Suffolk County Council (20031377)

Comments on the Applicant's Deadline 5 (D5) Submissions

Sunnica Energy Farm (EN010106)

30 January 2023

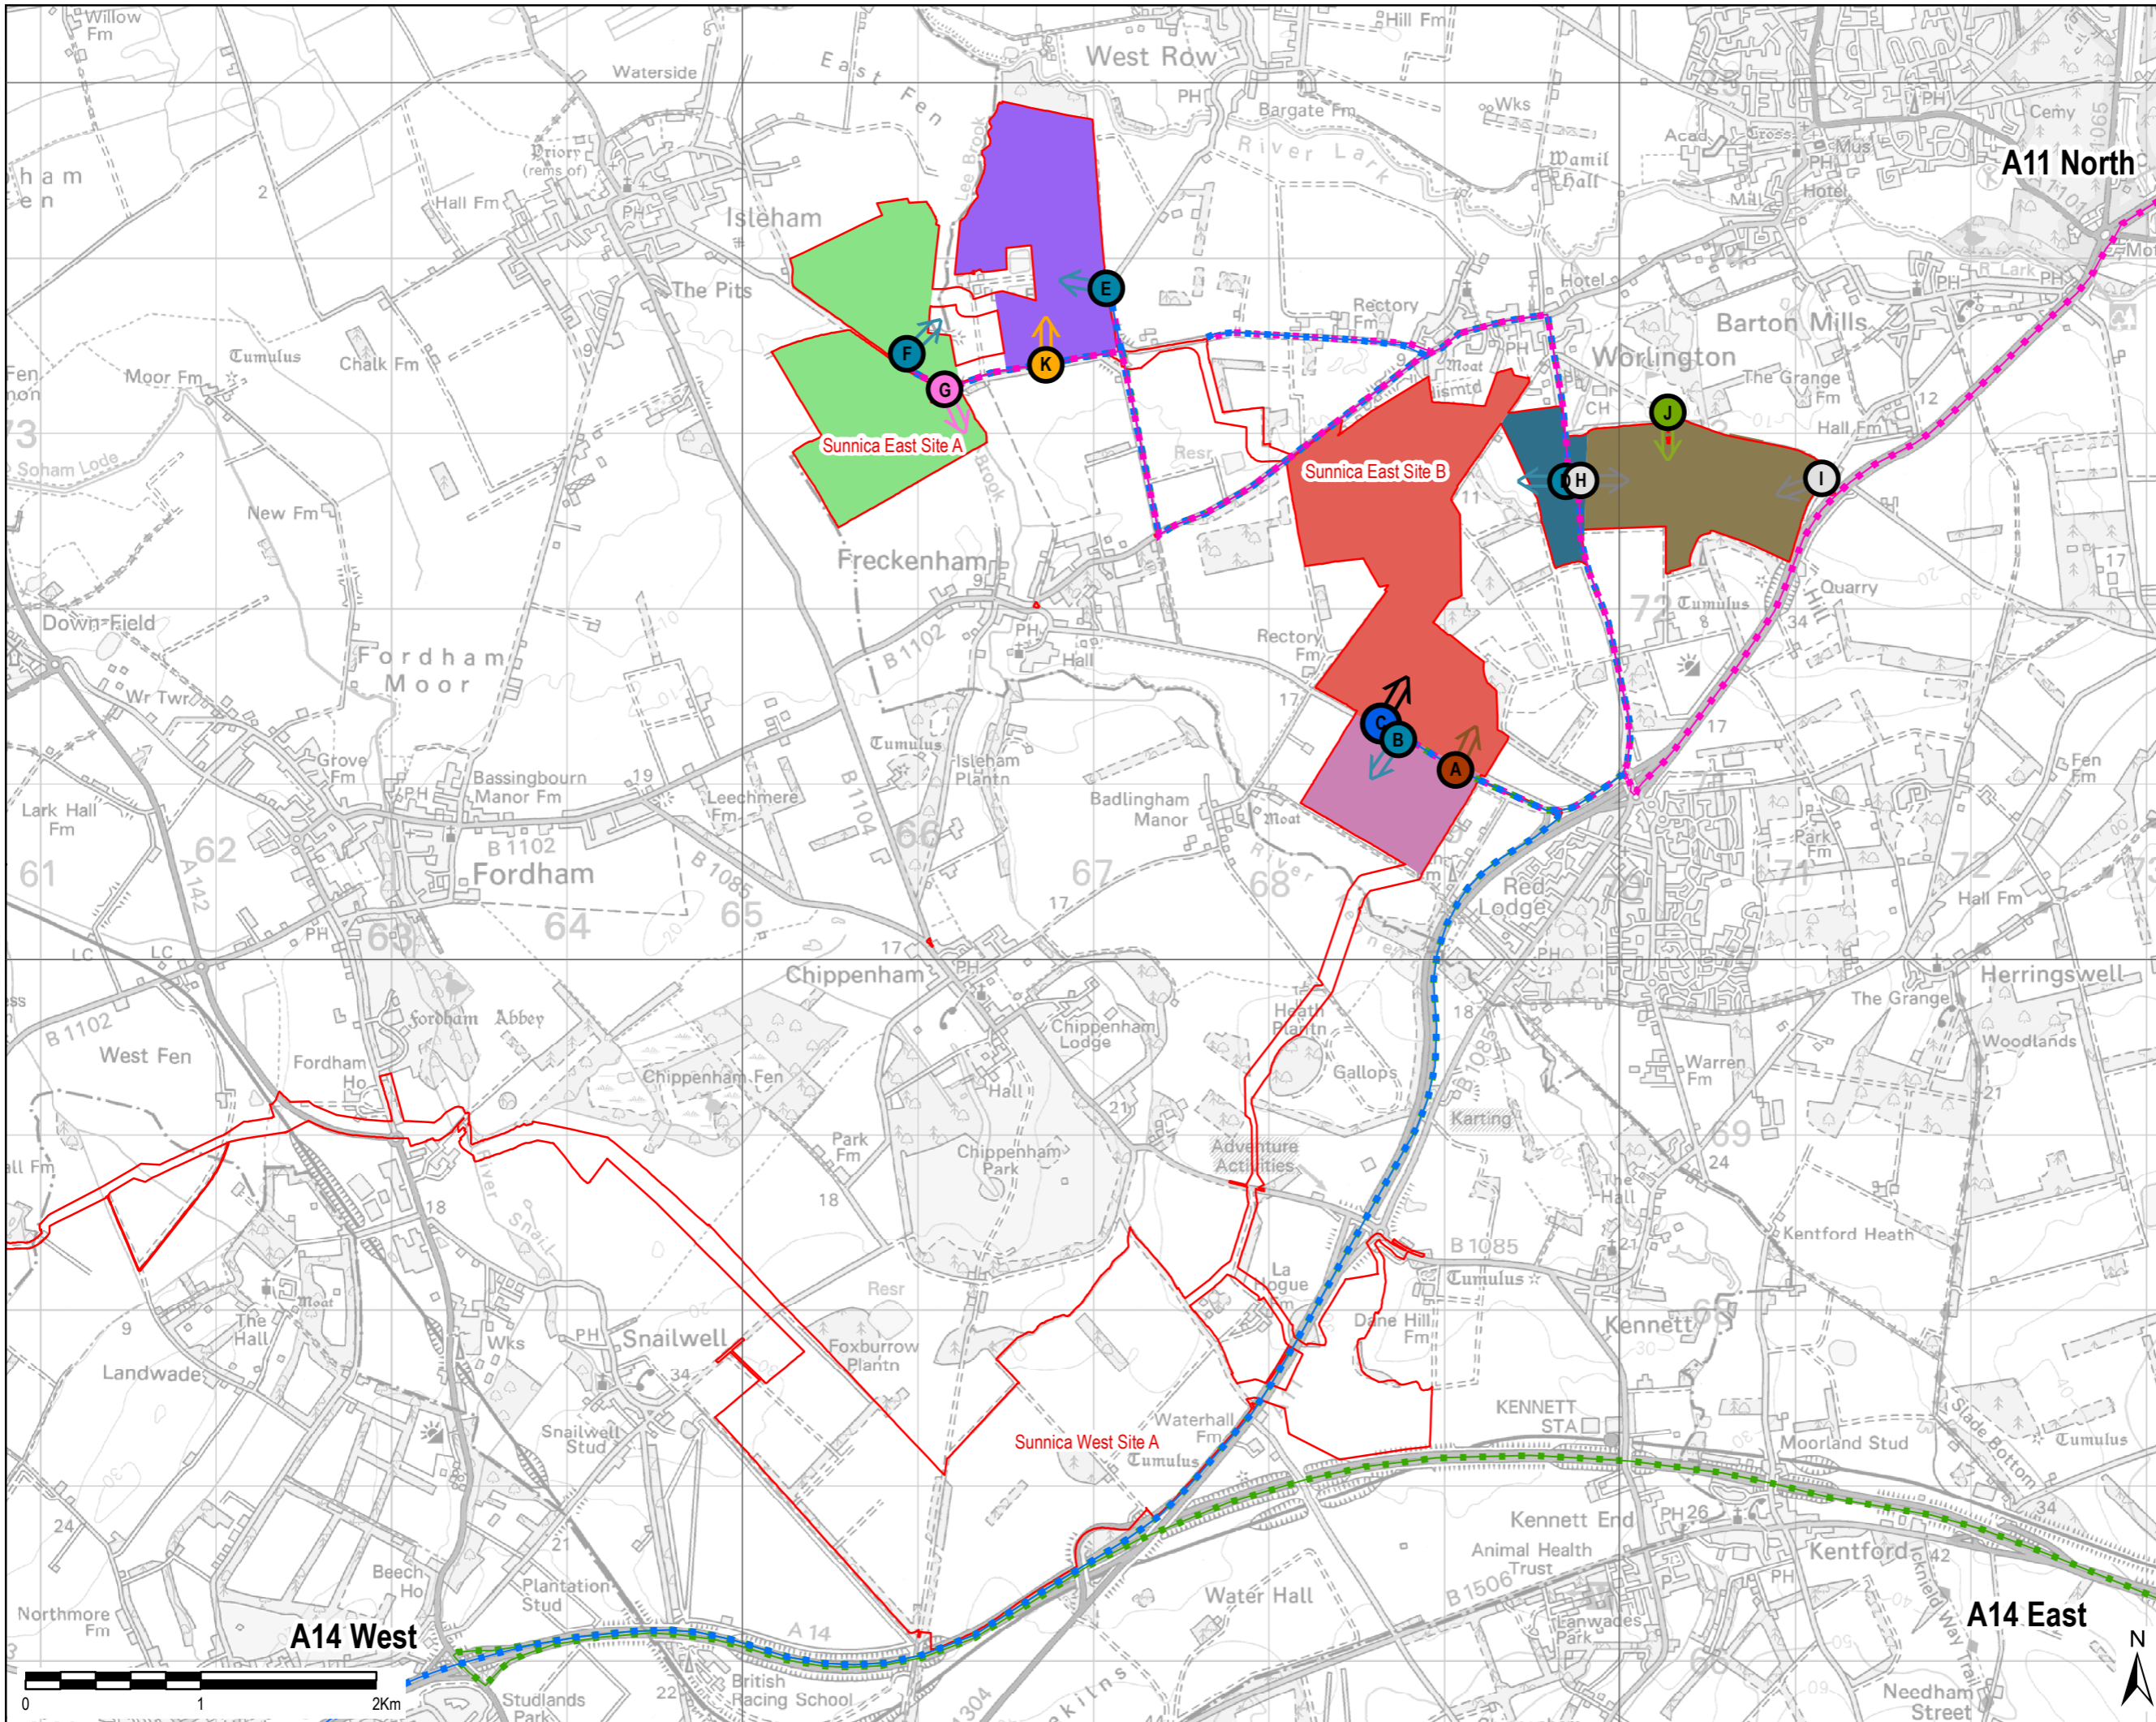
4.1.11	The Applicant states that for Sunnica East site accesses E and F: <i>'HGV vehicles routes are proposed to use Isleham Road to/from the A11 with the inbound and outbound routes shown in Figure 6 and Figure 7 respectively'</i> . Figures 6 and 7 show the route using the B1102 Freckenham Road Mildenhall Road and C603 Freckenham Road, not the C608 Isleham Road. It may be that Figures 6 and 7 may only be showing routes to grid connection T, but this is not clear as the plans only show accesses to the main site. Clarification is still required on the routing of HGVs on Isleham Road.
